Development Facilitation Team (DFT) – Review Comments

Project No: PR-2024-009956 **Date: 2/12/2025** **Agenda Item: #7** **Zone Atlas Page: M-9**
Legal Description: 1D, Town of Atrisco Grant, projected section 33 township 10 North range 2 East.
Request: Proposed site improvements for a new tenant building with a Taco Bell quick-service restaurant with accessory drive-thru on the end cap.
Location: 1115 Snow Vista Blvd between Sage Rd/De Vargas Rd and Benavides Rd.

Application For: SI-2024-01475 – SITE PLAN DFT

EAST ELEVATION	$1/8" = 1'-0"$	1
-----------------------	----------------	----------

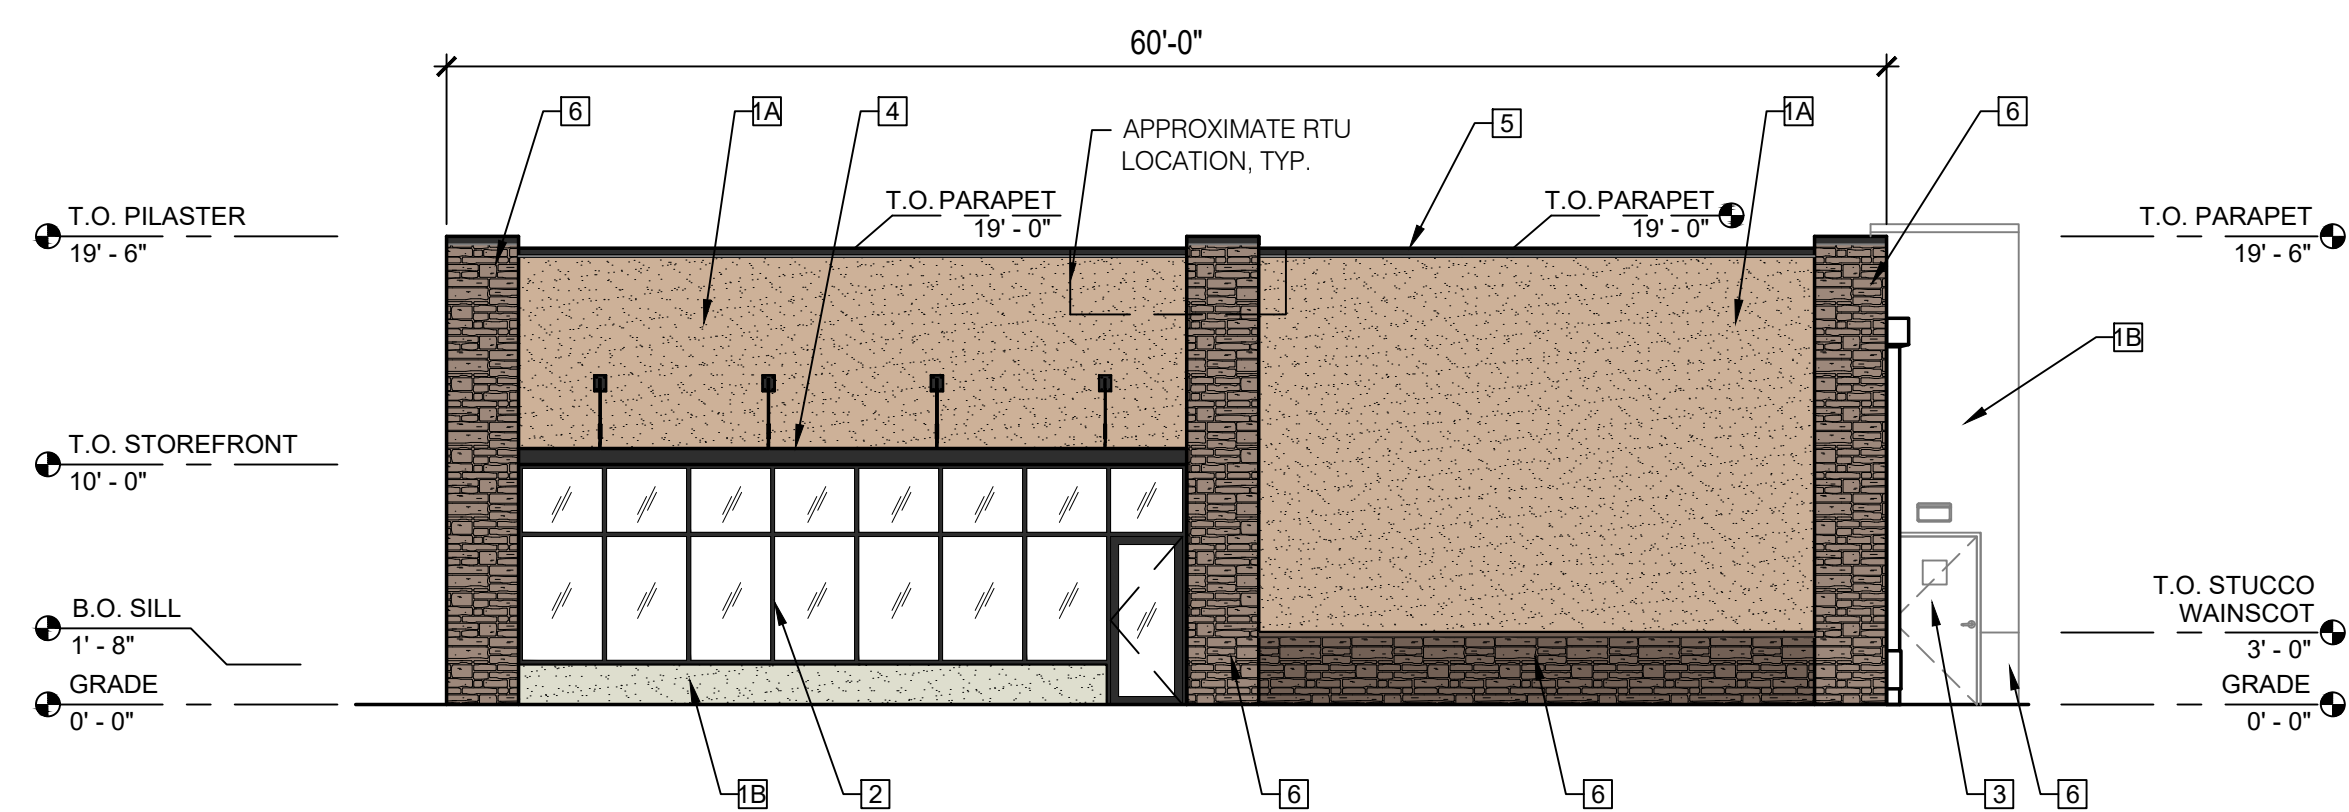
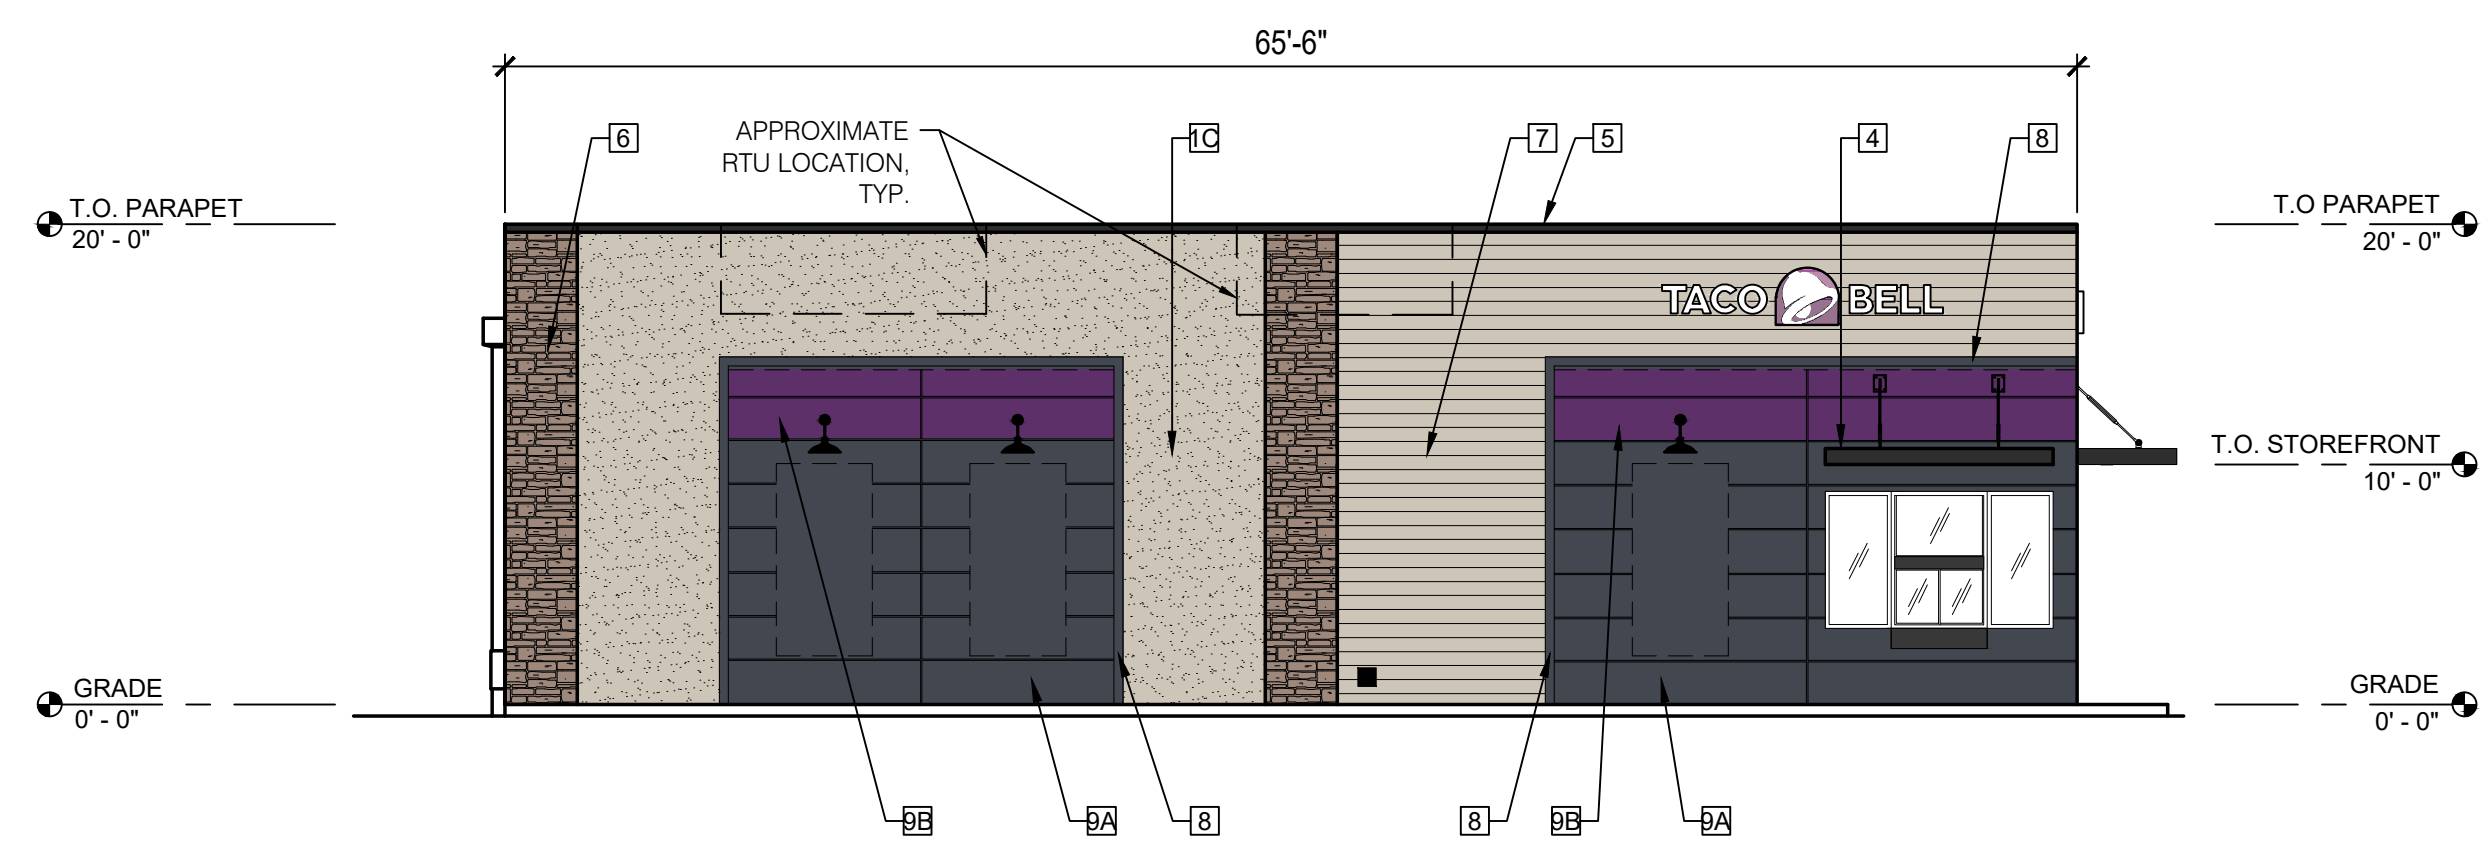
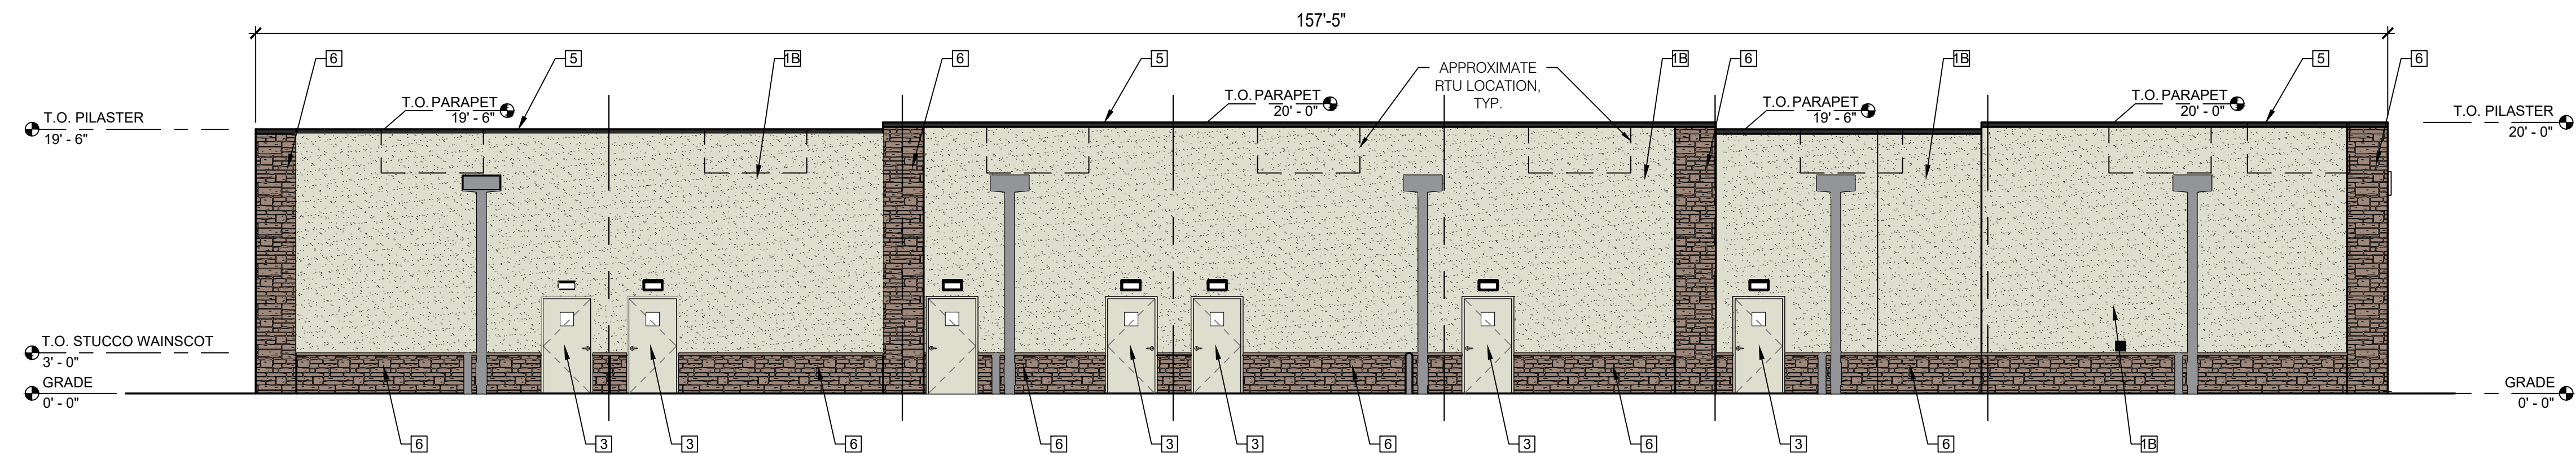
- This sites Drive-Through area goes along the sides and rear of the building. Additional detail is needed on elevation page or landscaping plan to demonstrate how the entire Drive-Through area meets the Use Specific Standards and screening requirements per IDO section 4-3-F-5 & 5-5-I. Along with Screening from trail and diversion channel per 5-2-I

Please see landscaping plans for drive-thru landscape screening details

# C400

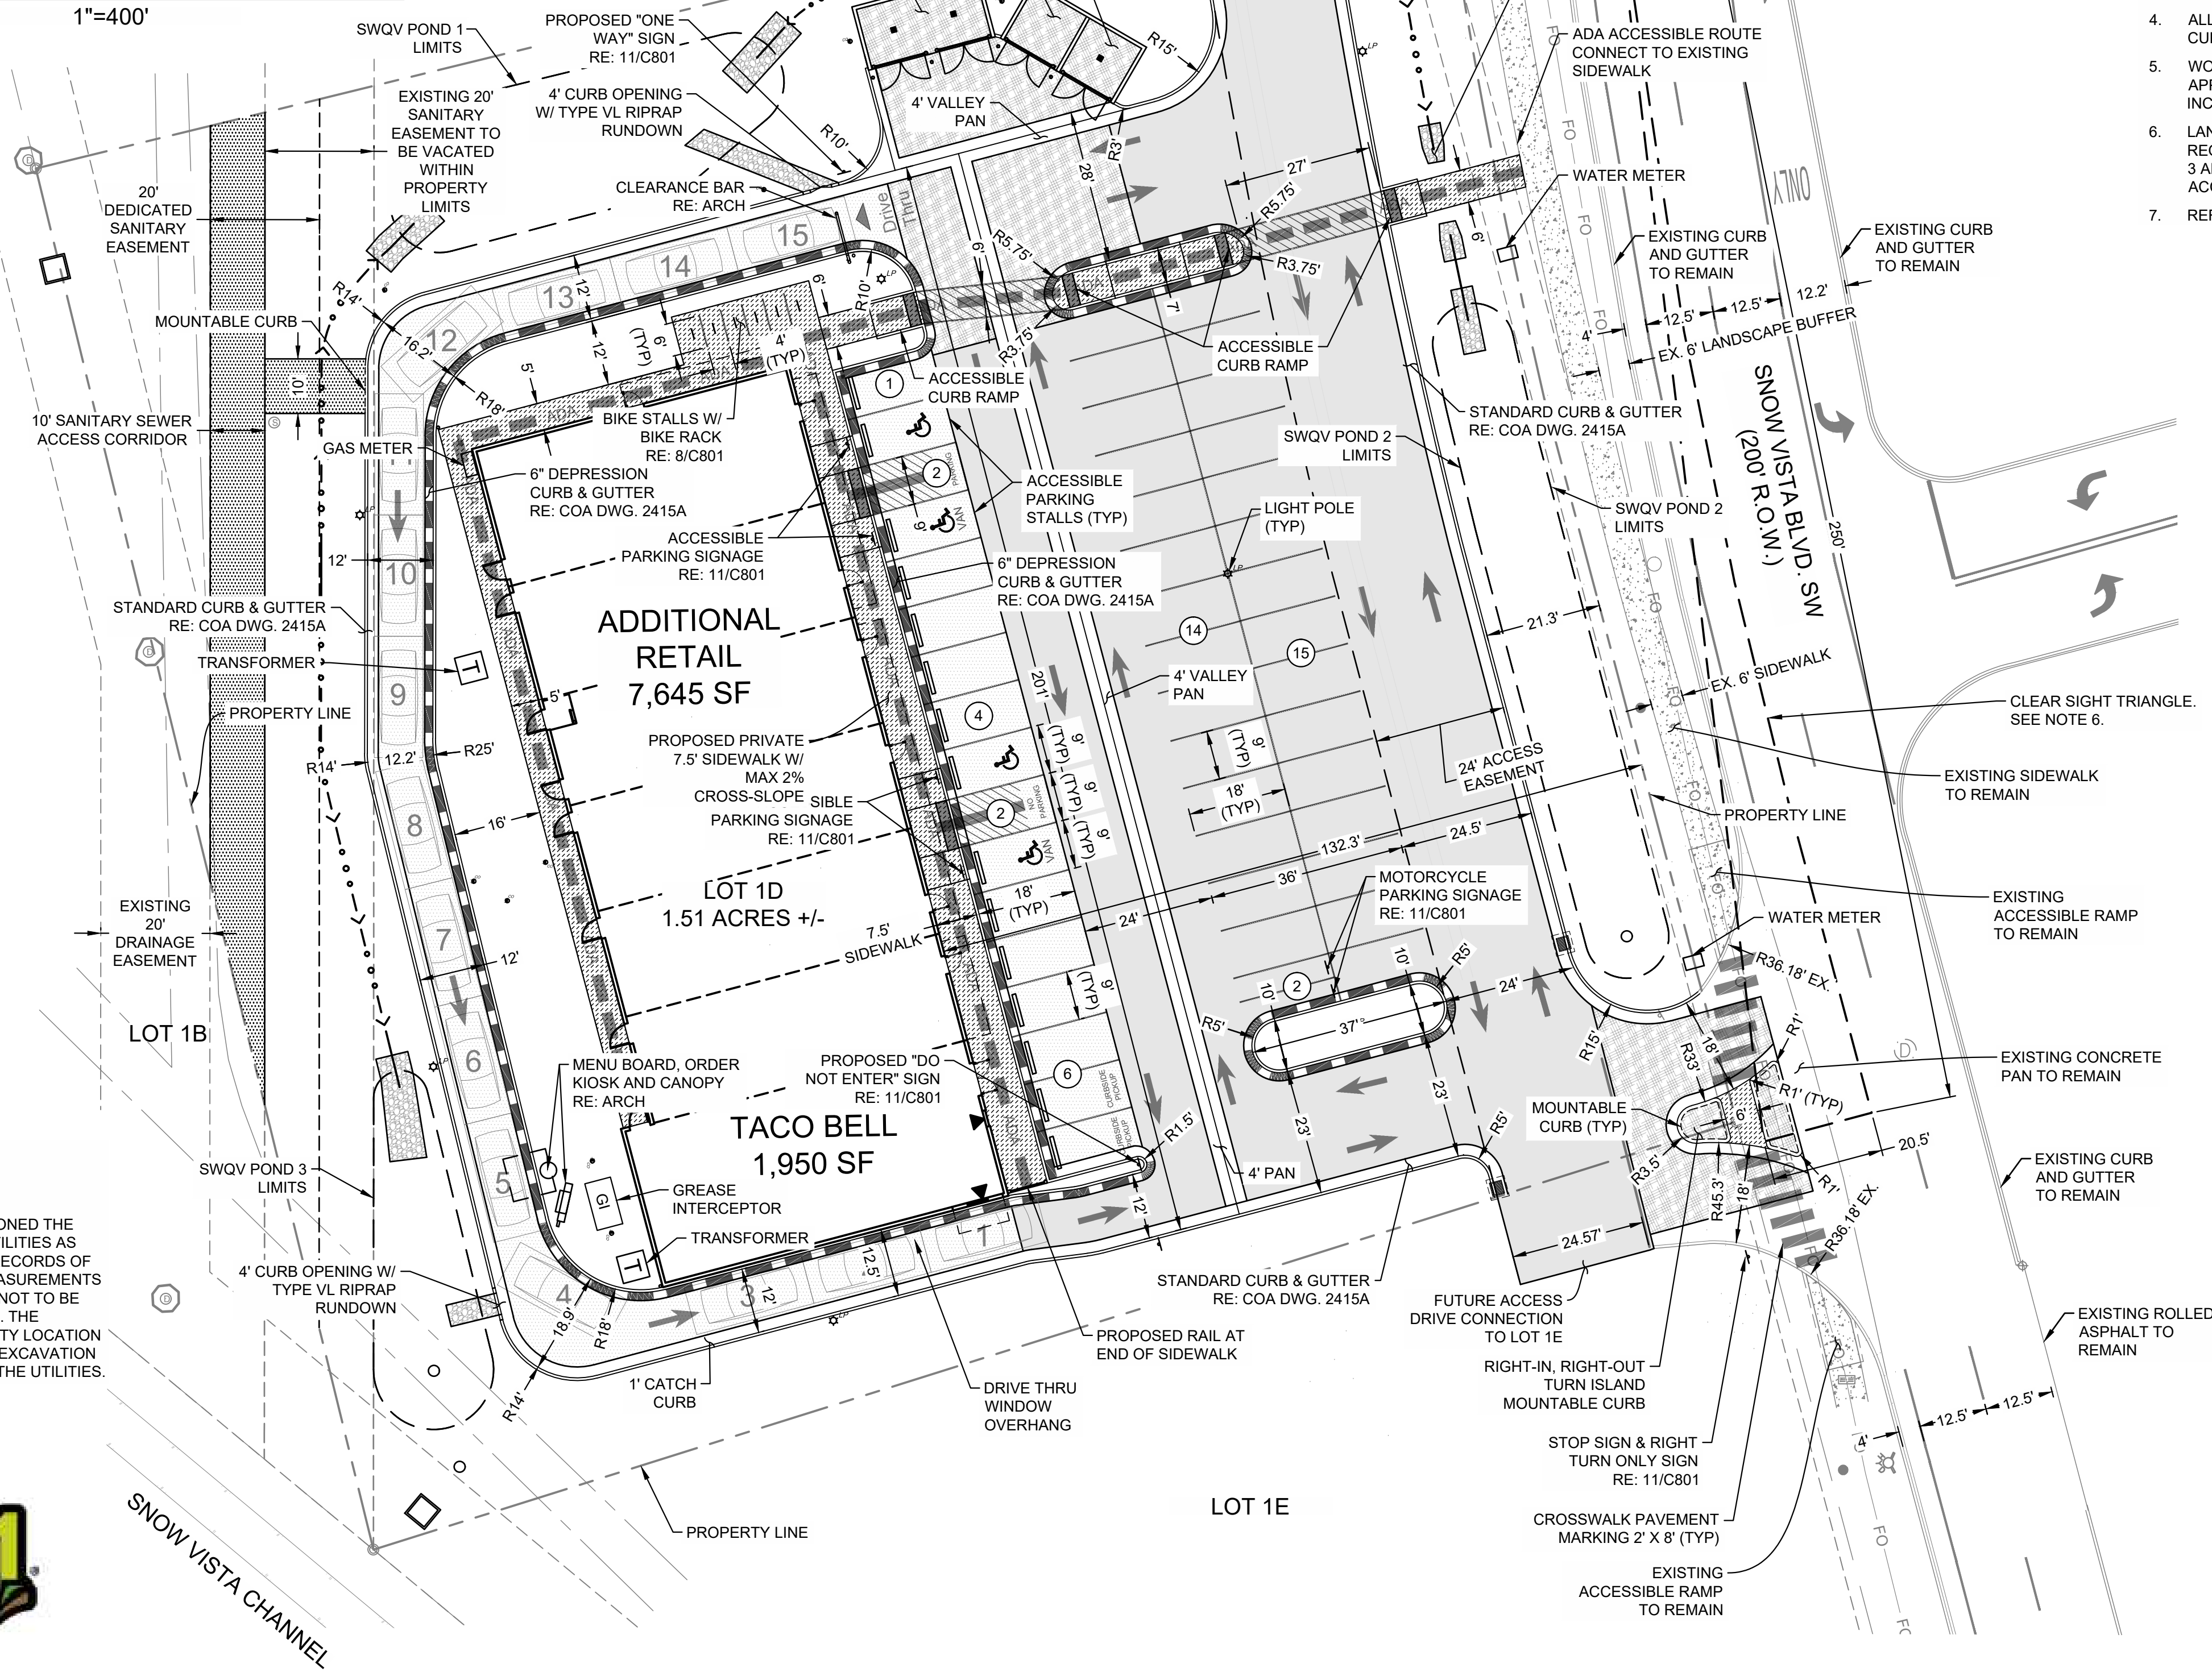
- *Please include a copy of the plat to ensure that there are cross lot access easements in place.*
- *Please show existing sidewalk and buffer along Snow Vista as this roadway is a Principal Arterial and requires 6' sidewalk with a 5' to 6' landscape buffer.*
- *Transportation has an approved TCL dated 6/18/2024, but the Traffic Scoping Form was not signed off prior to this. If a Traffic Study is required then the TCL may need to be modified to meet TIS recommendations. Transportation cannot sign off on site plan until then and the building permit will have a hold placed on*

THE PLAT IS INCLUDED WITH THE SUBMITTAL. THE EXISTING SIDEWALK AND BUFFER ARE LABELED ON THE SITE PLAN.
